HISTORIC PRESERVATION BOARD

July 12, 2006

Re: Side Entry Alterations – 37 Carroll Street

TRUMPED LUMBER
37 CARROLL ST.
SIDE VIEW

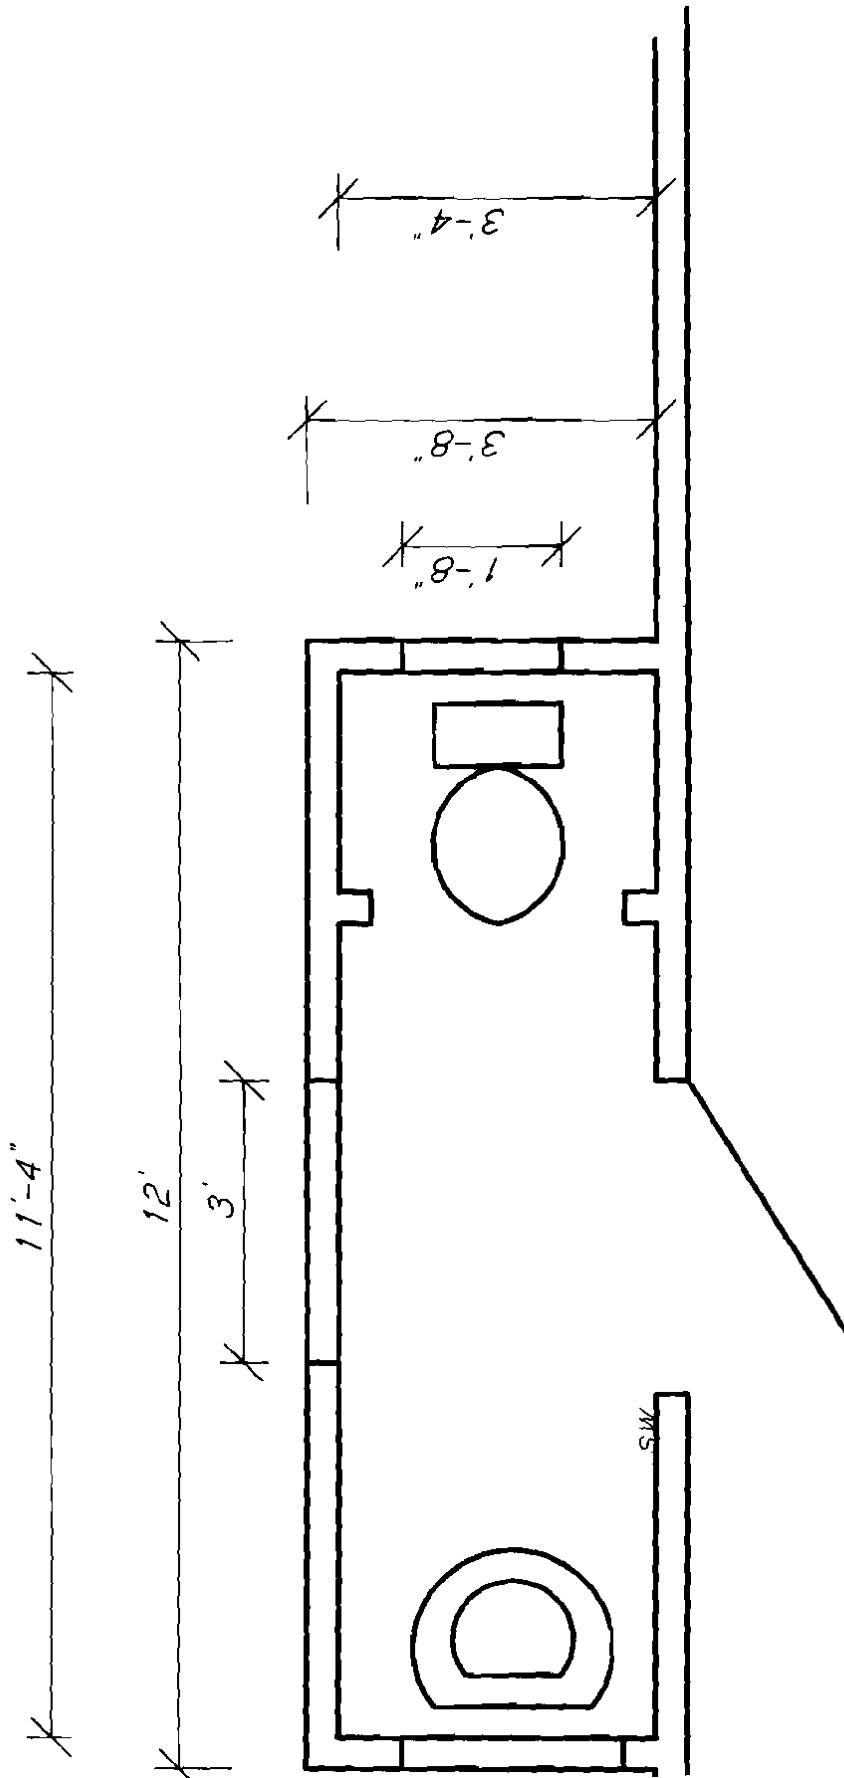
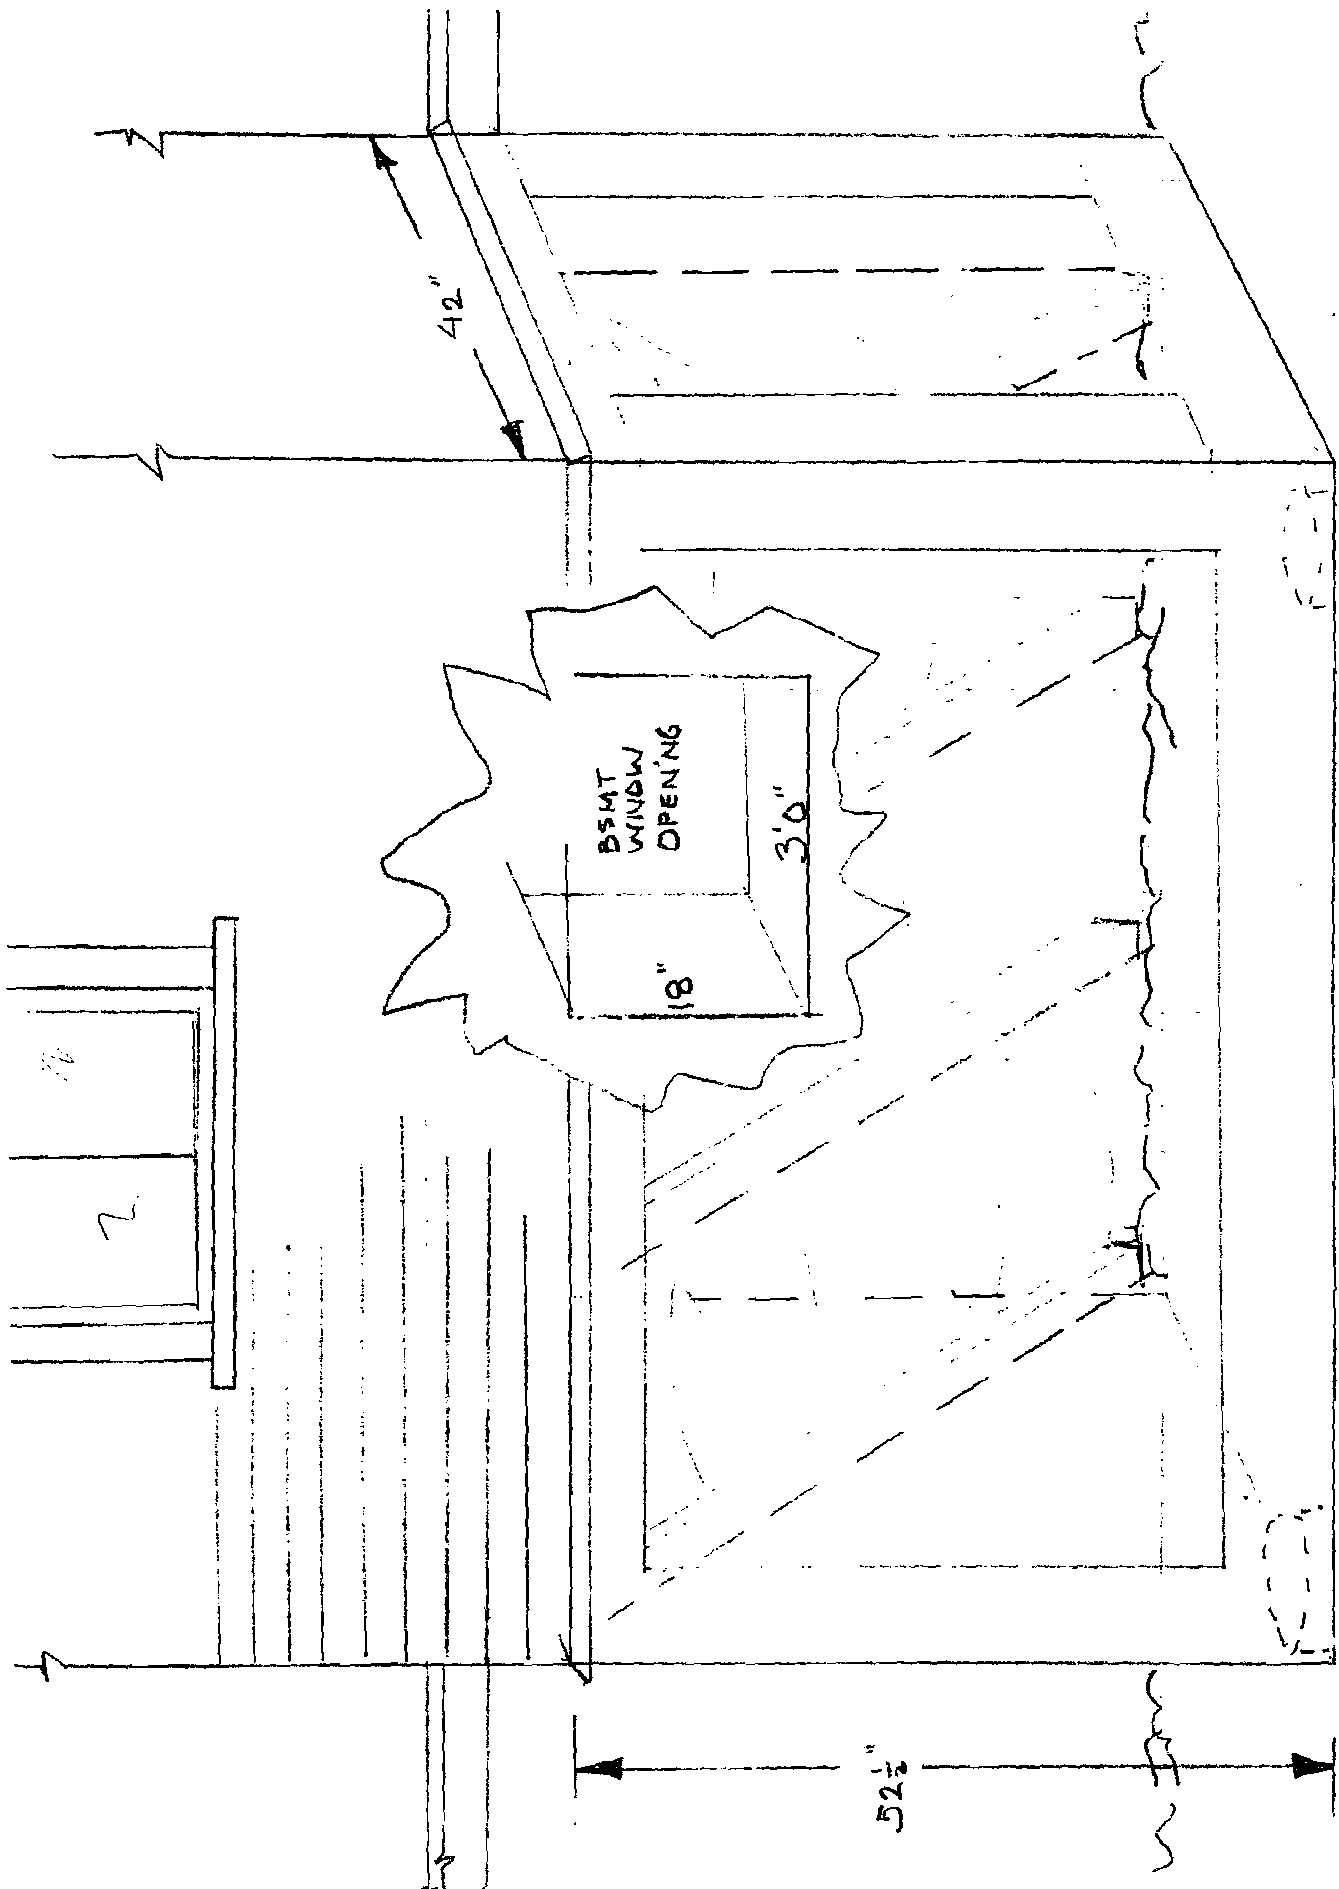
- The existing hood above the door to be removed and replaced with trim to match abutting trim detail.
- Applicant to install a window on the street-facing wall plane. Window to match the height of existing window on vestibule's west elevation; width of window to be adjusted for narrower width of front wall plane. Window to be 2/2 true divided light wood window to match existing —final window spec. to be submitted to staff for final approval. Window trim to match existing.
